# 1865 WOODMOOR DRIVE

### LANDSCAPE PLAN

LANDSCAPE PLAN

3  
OF 4

LANDSCAPE PLAN

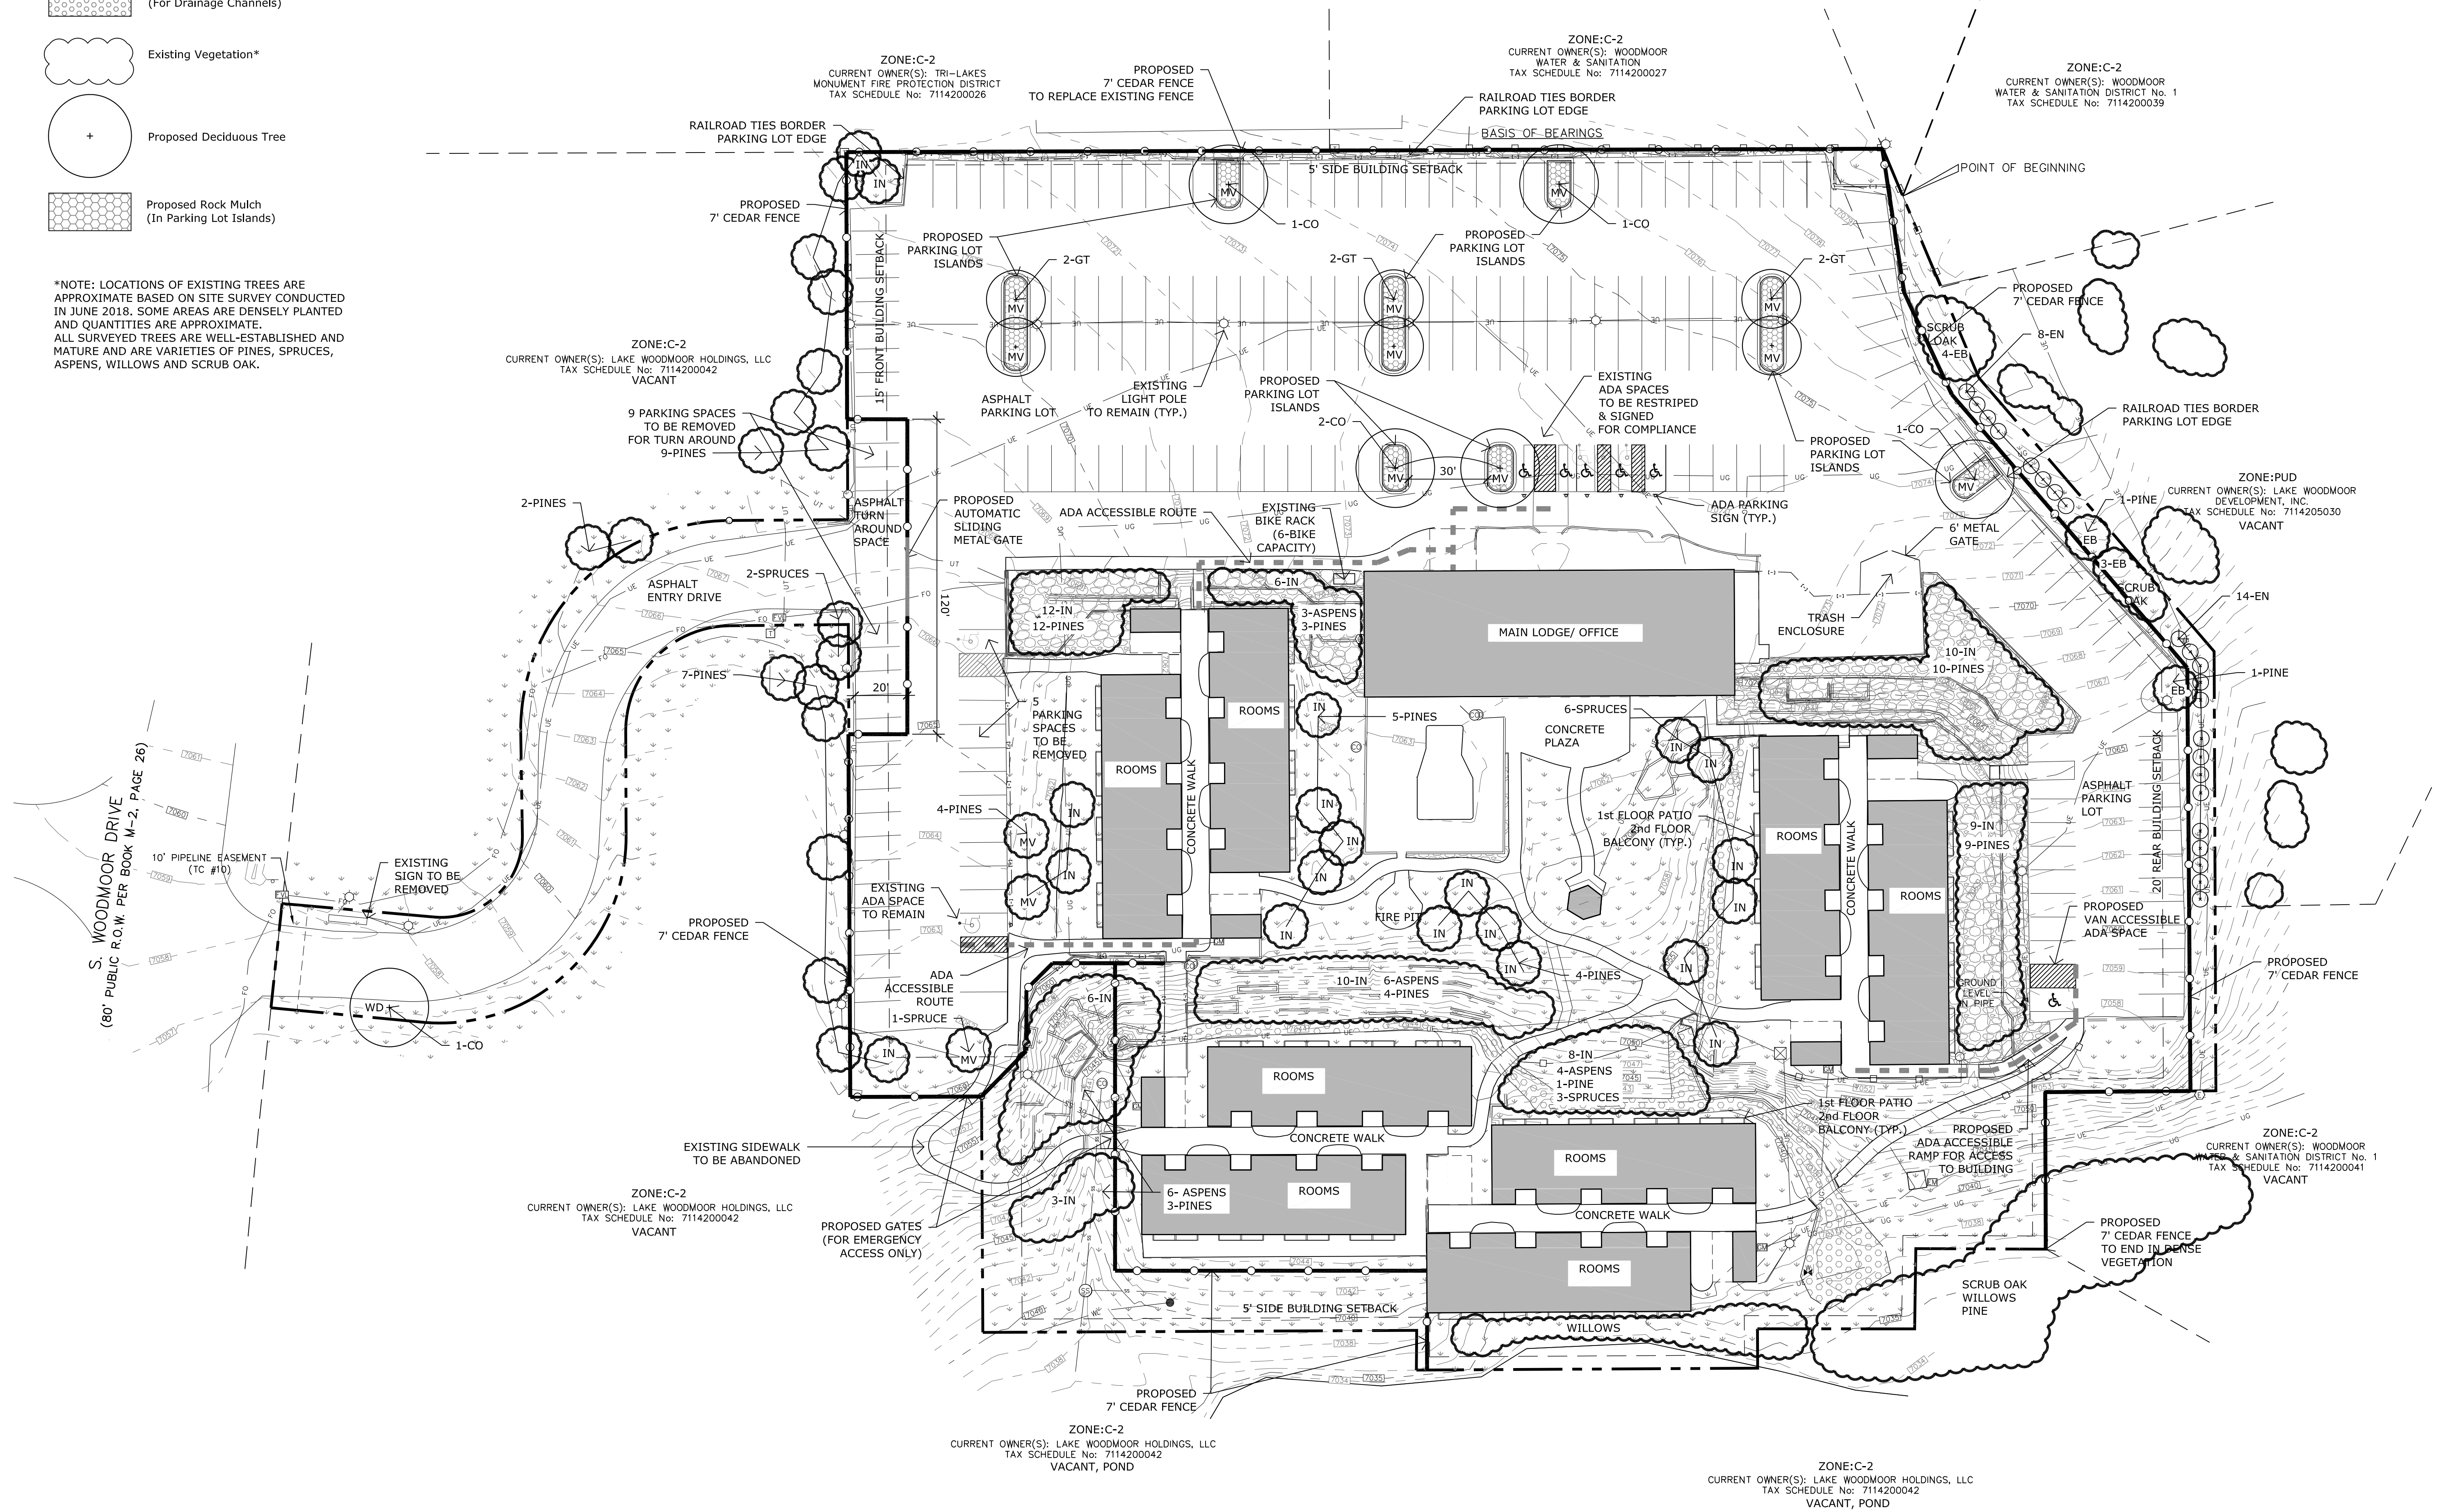
Please see the LDC requirements for landscaping along a zone district boundary and revise accordingly.  
Please also see the parking lot screening requirements.

What does IN, WD, MV, etc mean? If plant species please add to table. (Ex: 10-IN)

Provide Easement, because this path crosses onto the adjacent property.

Provide Roadway landscaping tree(s), but do not located them within the easement.  
If entry feature landscaping is proposed please provide an additional detail.

At th neighborhood meeting it was indicated that the fencing type would be amended to be a 7 foot privacy fence. Verify Fence Type.
